Blacktown City Council

21 May 2012

North West Rail Link Environmental Impact Statement Stage 1 – Major Civil Construction Works

SUBMISSION ON THE NORTH WEST RAIL LINK ENVIRONMENTAL IMPACT STATEMENT – STAGE 1

Figure 4.14 Cudgegong Station and Tallawong Stabling Facilities Heavy Vehicle Routes

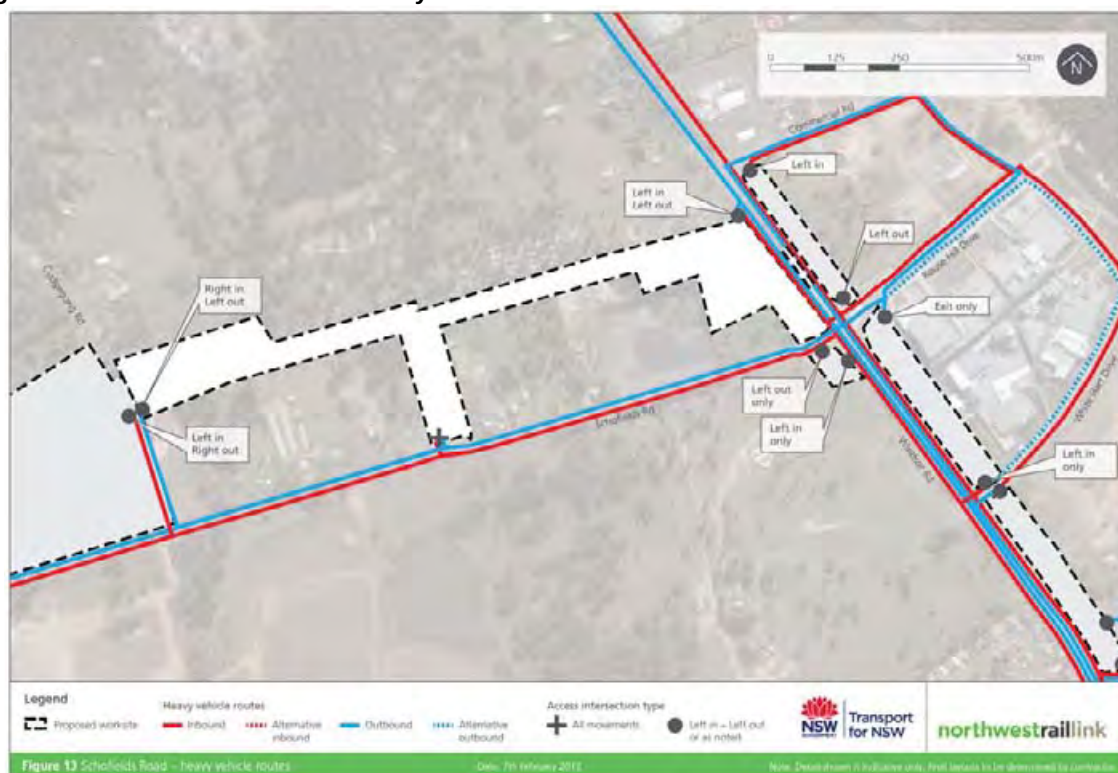
- Windsor Road Viaduct to Cudgegong Road
 - Tallawong Stabling Facility
- d) Access to the sites is proposed from Cudgegong Road, Tallawong Road and Schofields Road. The provision of two access points to each site is considered adequate with appropriate controls to manage truck movements in and out of the site.

- e) The EIS indicates that the Tallawong Stabling Facility will be the main generator of construction traffic. As such, extra care is needed to manage truck movements at this site.

- f) The EIS also indicates that heavy vehicles should follow the arterial road network – ie. Schofields Road and Windsor Road, noting that Schofields Road west of the construction sites does not provide direct connectivity to the arterial road network. In this regard, Council supports the heavy vehicle routes identified in the EIS.
